City of Albuquerque SWPPP Inspection Checklist

Project Name:	<i>Guthrie's Garage</i>	Project Operator:	<i>Jim Guthrie</i>
Project Location:	<i>3831 Masthead</i>	Contact Name:	
NPDES Permit Number:	<i>NMR 1005 R0</i>	Contact Number:	
Date of Inspection:	<i>7/13/23</i>	Contact Email:

ENGINEER'S SEAL RONALD R. BOHANNAN NEW MEXICO PROFESSIONAL ENGINEER 7868 4-17-23 RONALD R. BOHANNAN P.E. #7868	3831 MASTHEAD ST ALBUQUERQUE, NM	DRAWN BY pm
EROSION CONTROL PLAN		DATE 4-17-23
		DRAWING
		SHEET # SW-1
		JOB # 2022002

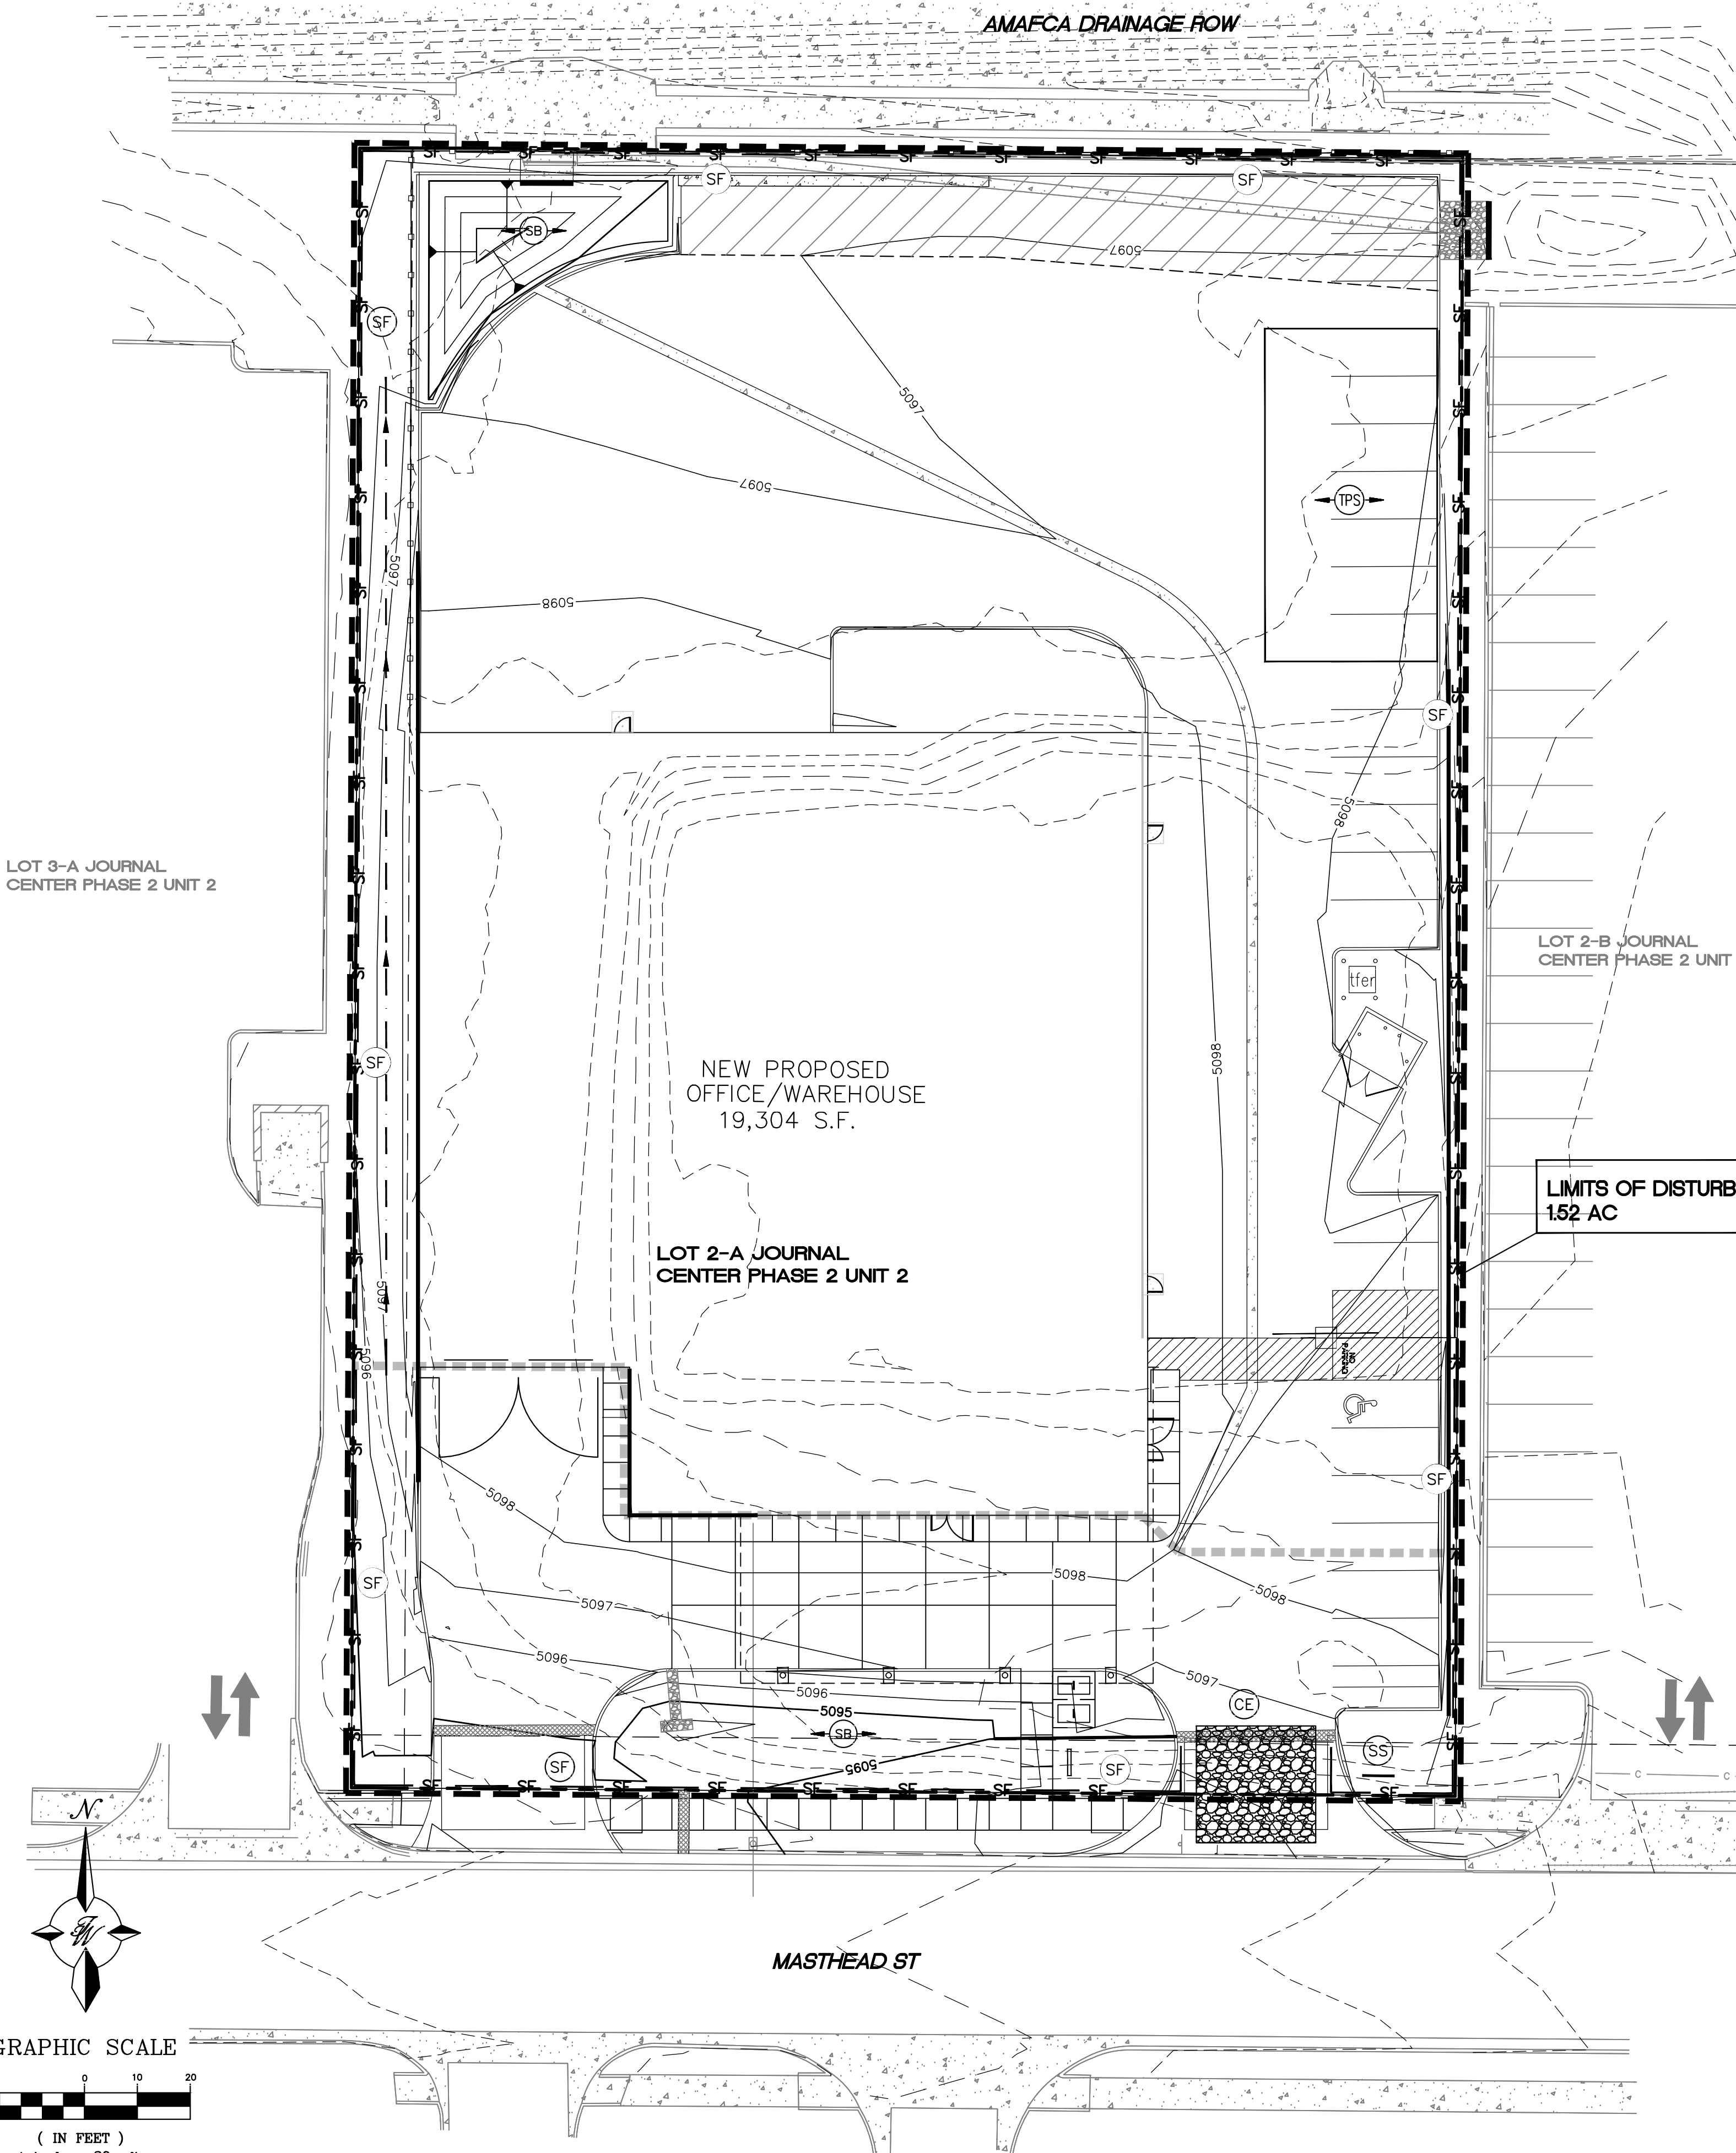
SWPPP Requirements	CGP (SWPPP)	YES	NO	COMMENTS
Have all operators (I.11.1) using the SWPPP signed the Certification Statement (I.11.4)?	7.2.10 (Sec 8)	<input type="checkbox"/>	<input checked="" type="checkbox"/>	
If multiple Operators are sharing a SWPPP, are the individual's areas of control identified?	7.2.1 (Sec 1)	<input checked="" type="checkbox"/>	<input type="checkbox"/>	XXXXXX
Has the Operator (I.11.1) signed a Delegation of Authority (I.11.2) so an employee can sign reports?	I.11.2 (Sec 6) (App J)	<input type="checkbox"/>	<input checked="" type="checkbox"/>	<i>N/A</i>
Are the Stormwater Team members identified? E-mail? Phone#?	6 7.2.2 (Sec 1.2, 6)	<input type="checkbox"/>	<input checked="" type="checkbox"/>	
Training for 1)BMP designer 2)Chemical Storage 3)Inspector 4)Corrective actions	6, & 7.2.8 (Sec 7) (App I)	<input type="checkbox"/>	<input checked="" type="checkbox"/>	<i>Brad Frosch QCIS certificate is only Certi - Items 1,2,&4 not identified</i>

The NOI for each operator	7.2.11 (App C)	<input checked="" type="checkbox"/>	<input type="checkbox"/>	
Is a copy of the CGP included or available onsite to all team members?	7.2.11 (App B)	<input checked="" type="checkbox"/>	<input type="checkbox"/>	
Is there a schedule of project activities with start/end dates?	7.2.3	<input type="checkbox"/>	<input type="checkbox"/>	<i>? Didn't See One</i>
Has the site map been updated?	7.2.4 (App A)	<input type="checkbox"/>	<input checked="" type="checkbox"/>	
SWPPP modifications must be recertified by operators.	7.4.2, 7.4.3 I.11.4 (App F)	<input type="checkbox"/>	<input type="checkbox"/>	<i>N/A</i>
Are maintenance/corrective action logs updated?	2.1.4, 5.4 (App E)	<input type="checkbox"/>	<input checked="" type="checkbox"/>	
Are self-inspection reports included and signed?	4.7, 4.7.2 (App D)	<input type="checkbox"/>	<input checked="" type="checkbox"/>	
Stabilization –Specific Practices & Activities Log	7.2.6.vi (App H)	<input type="checkbox"/>	<input type="checkbox"/>	<i>? Didn't See One</i>
